2019 Financial Assurance Estimate Form (with Construction)

PROJECT INFORMATION				
The Trails at Aspen Ridge Filing No. 2	11/6/2019	\$	389,310.00	PUDSP-191
Project Name	Date			PCD File No.

GRADING & EROSION CONTROL PLAN

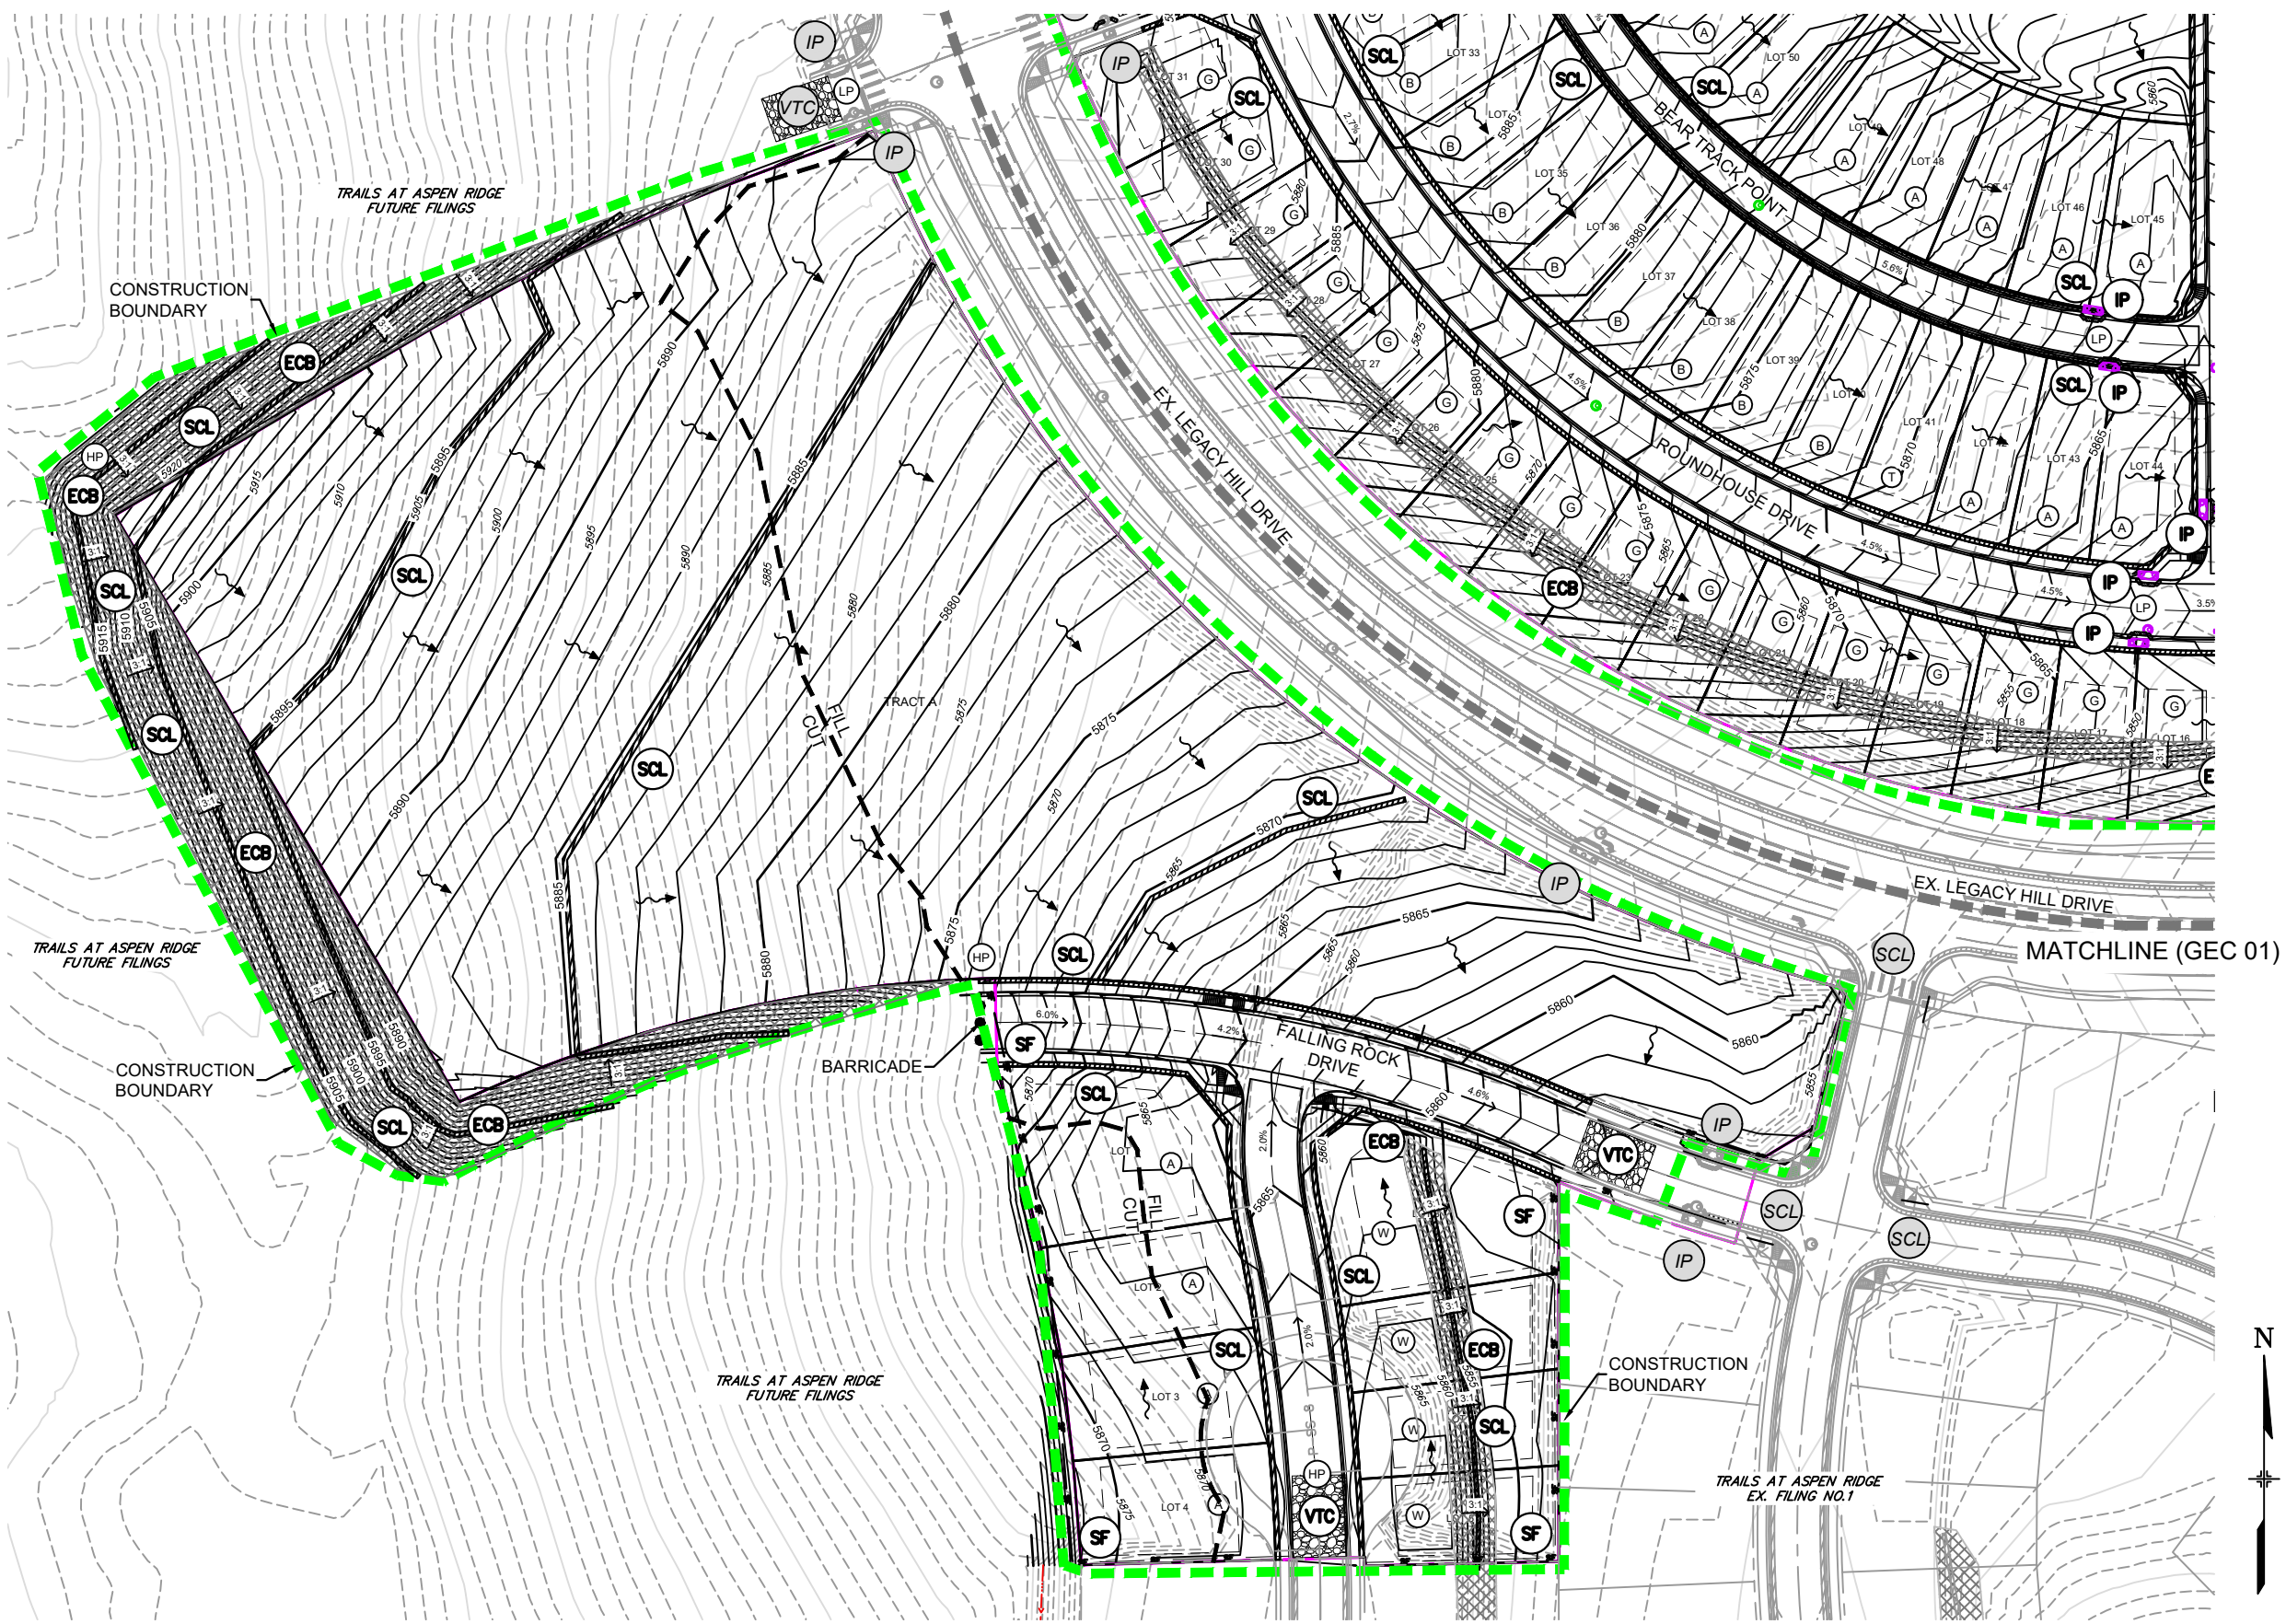
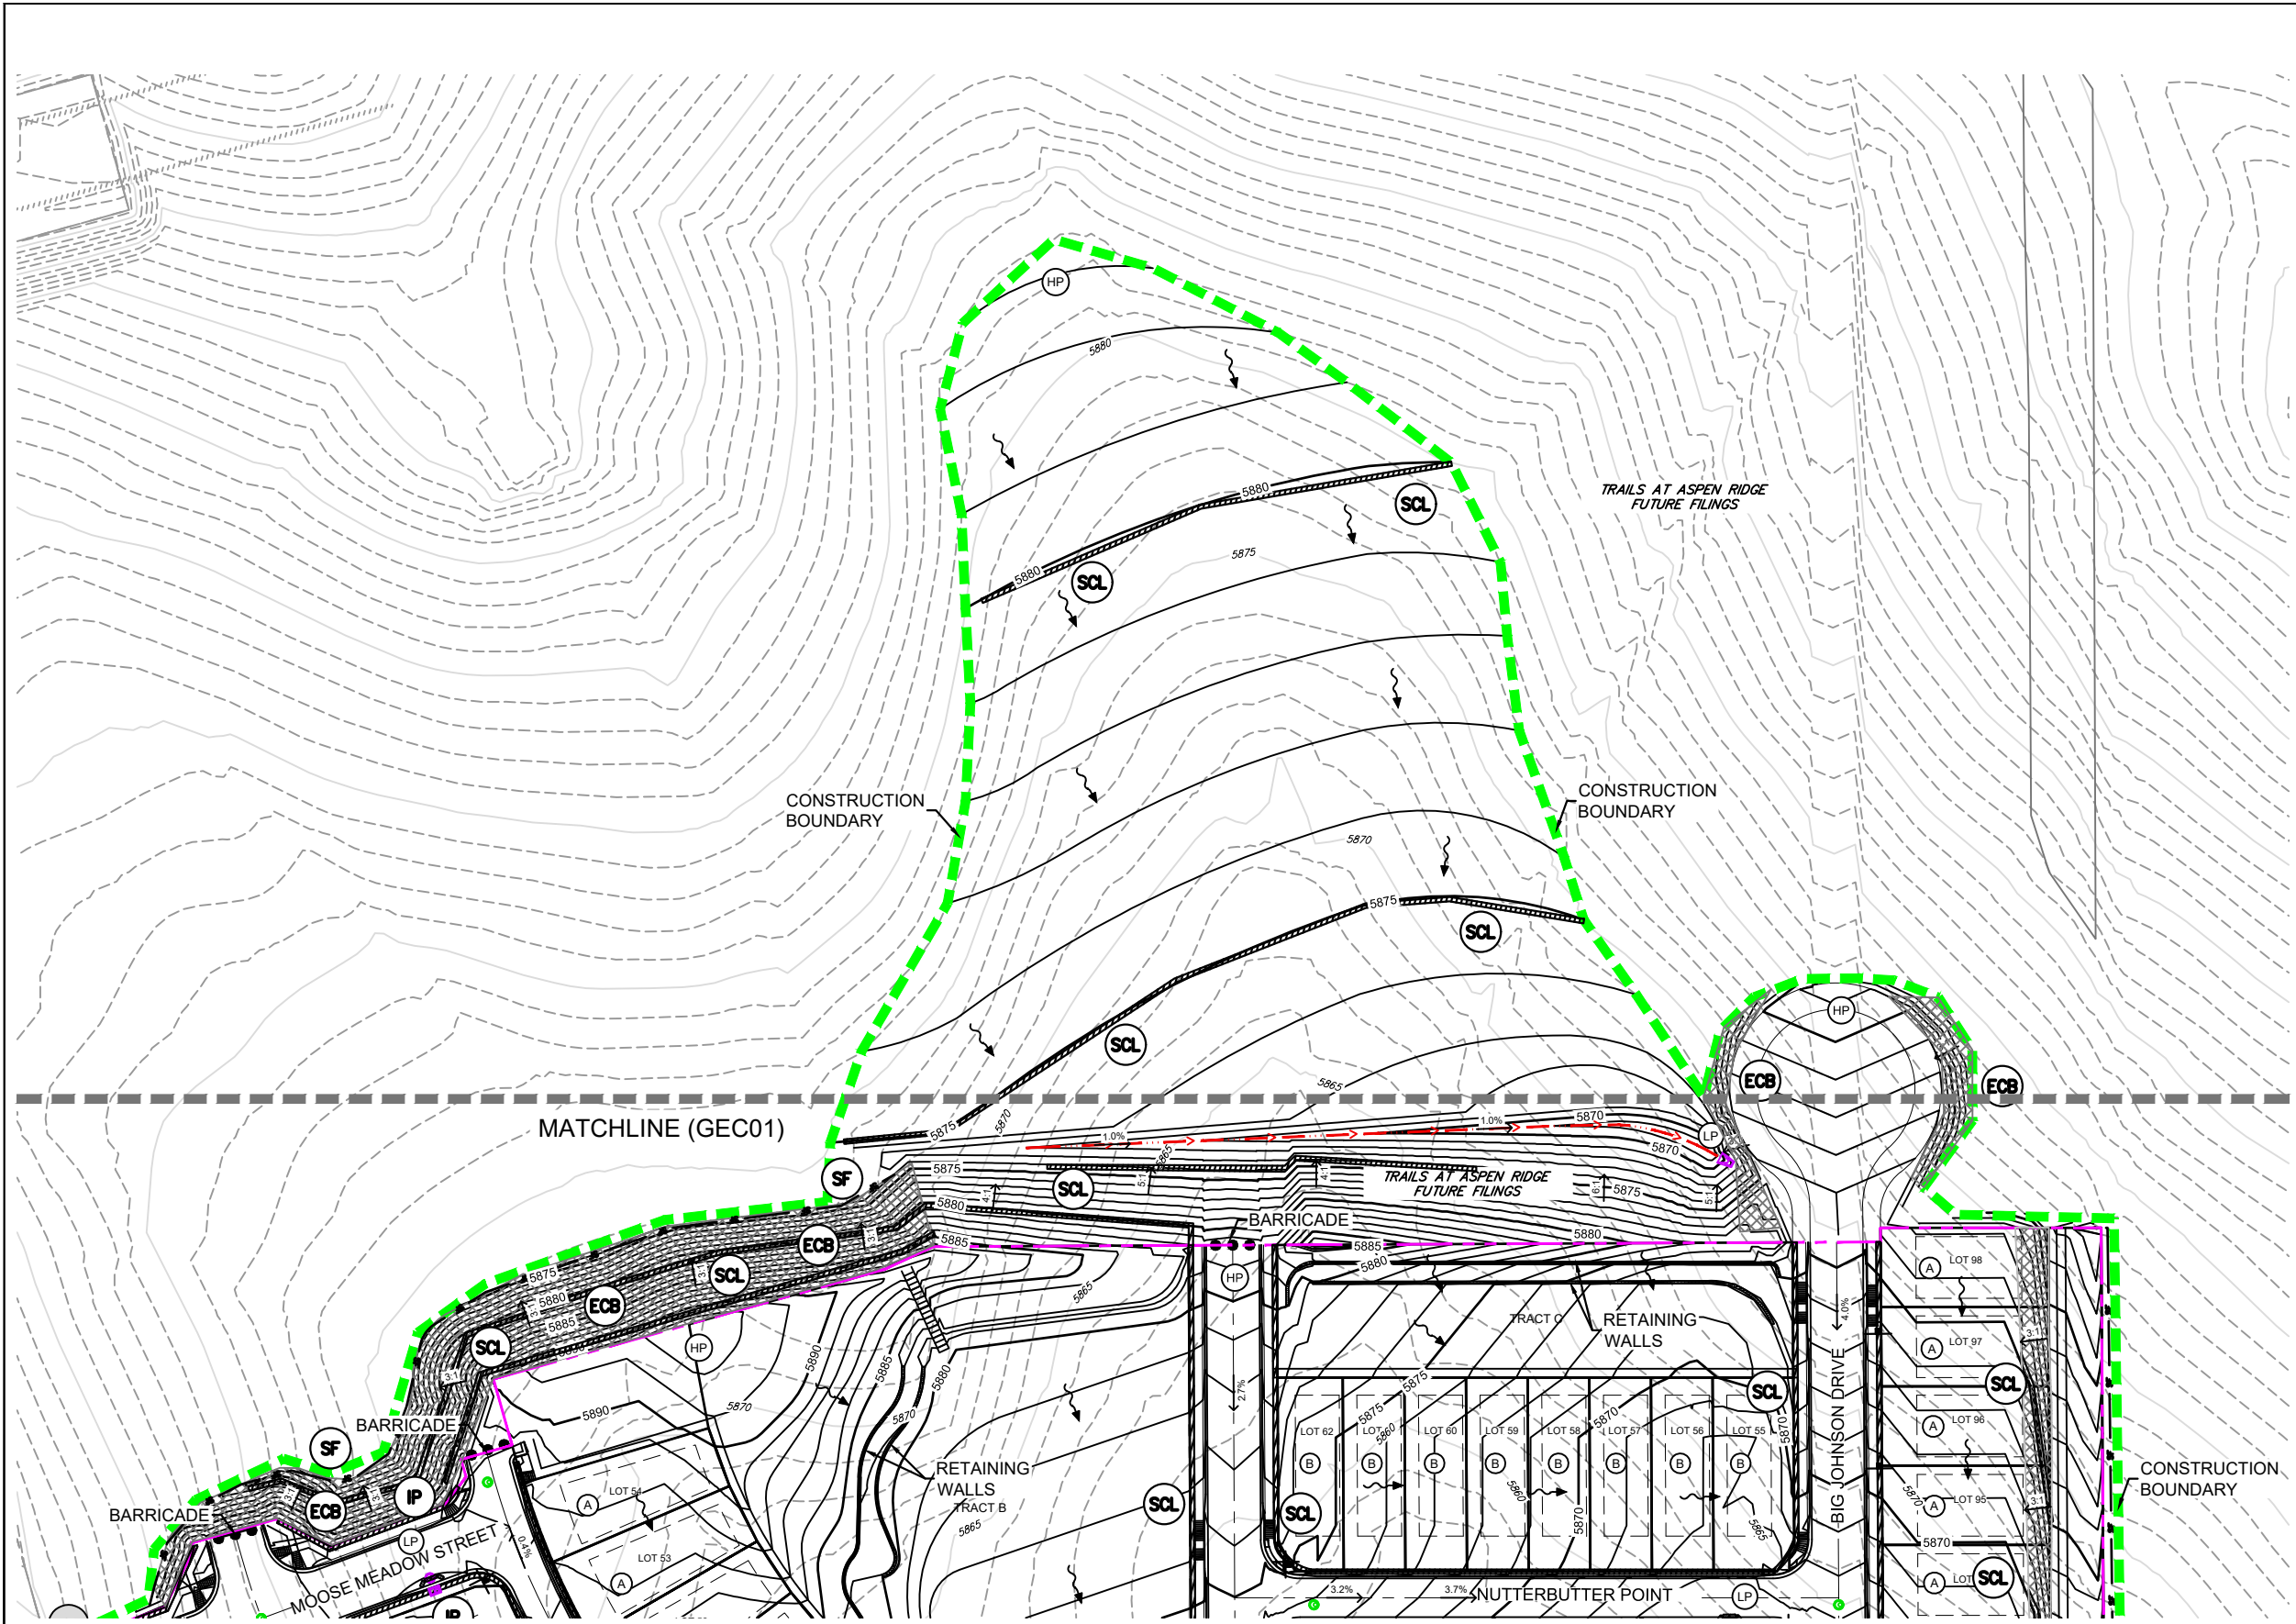
update the items and quantities accordingly per comments on the GEC plan.

There are 13 inlet protections shown on the GEC plan. Please revise.

FAE revised accordingly
